23 rd April 2022.

Re: Inspectorate for A417

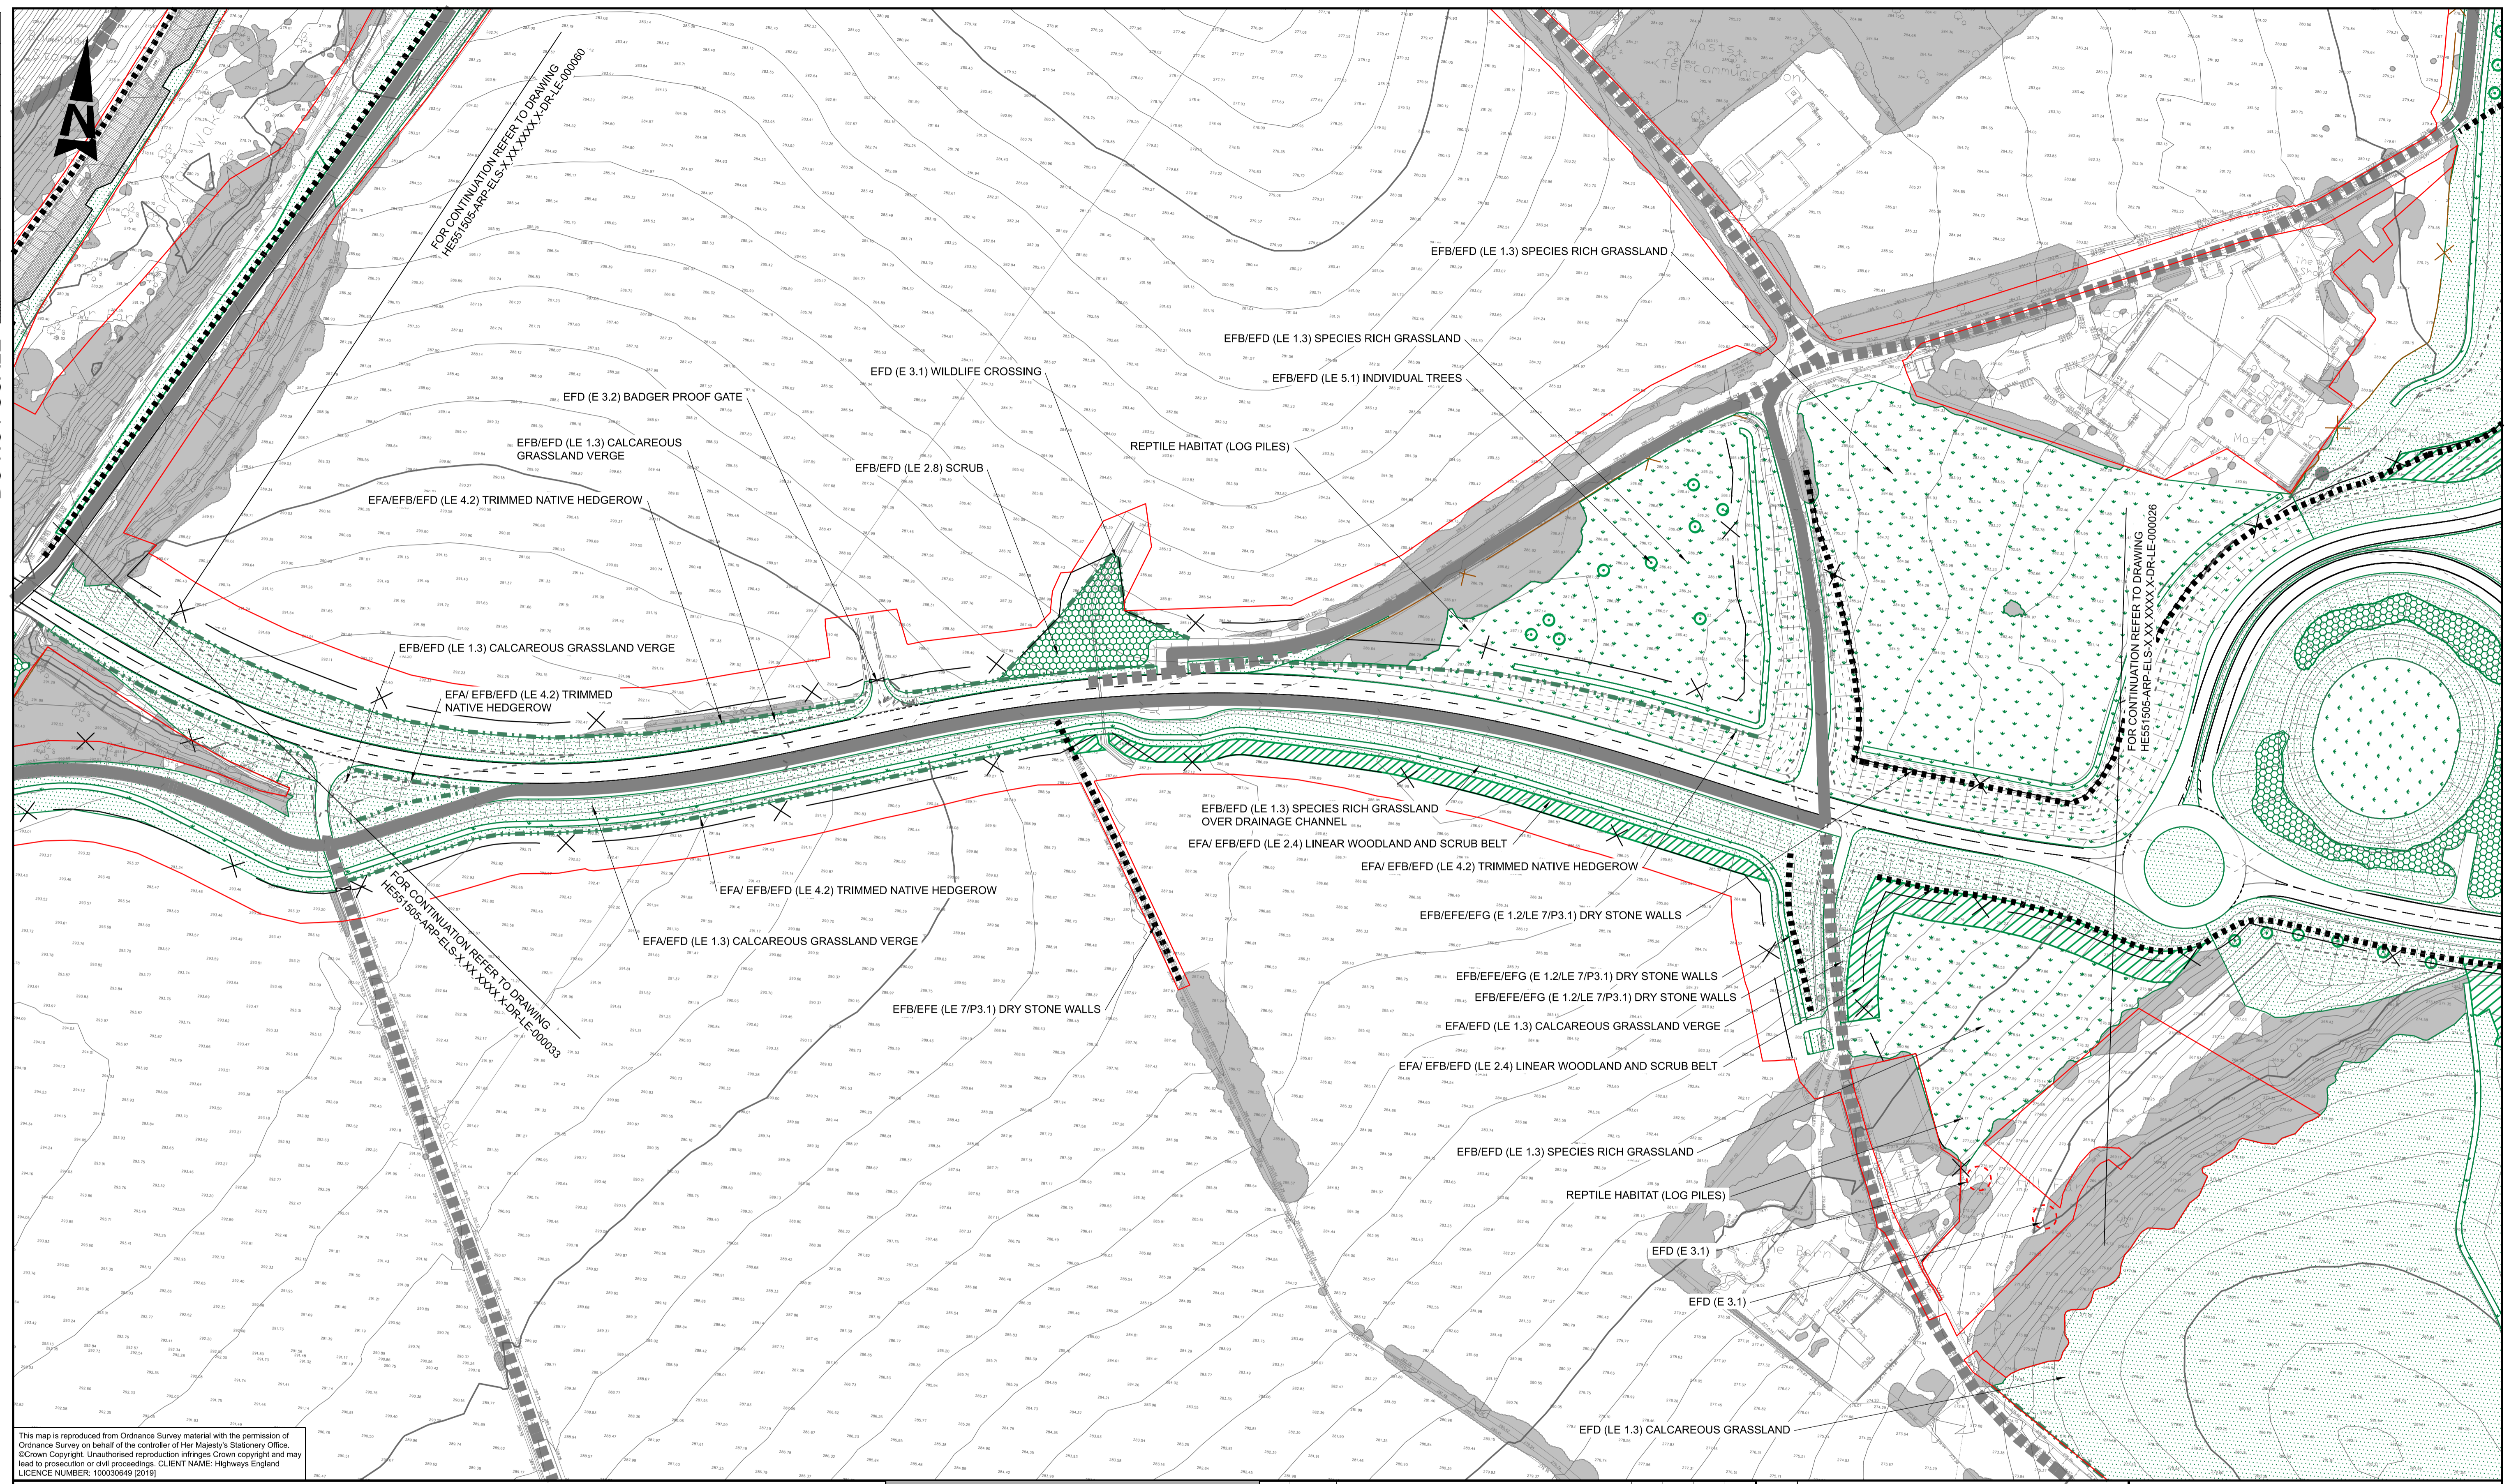
5. There is no need for a bund at the South West side of my front field against the road which leads to my Farm buildings [REDACTED], only tree planting is required. Reason, it will become a litter trap which will be difficult to keep clean on a slope also being a slope it will encourage rabbits to burrow and difficult to control. All fencing to tree enclosures should have rabbit fencing included.
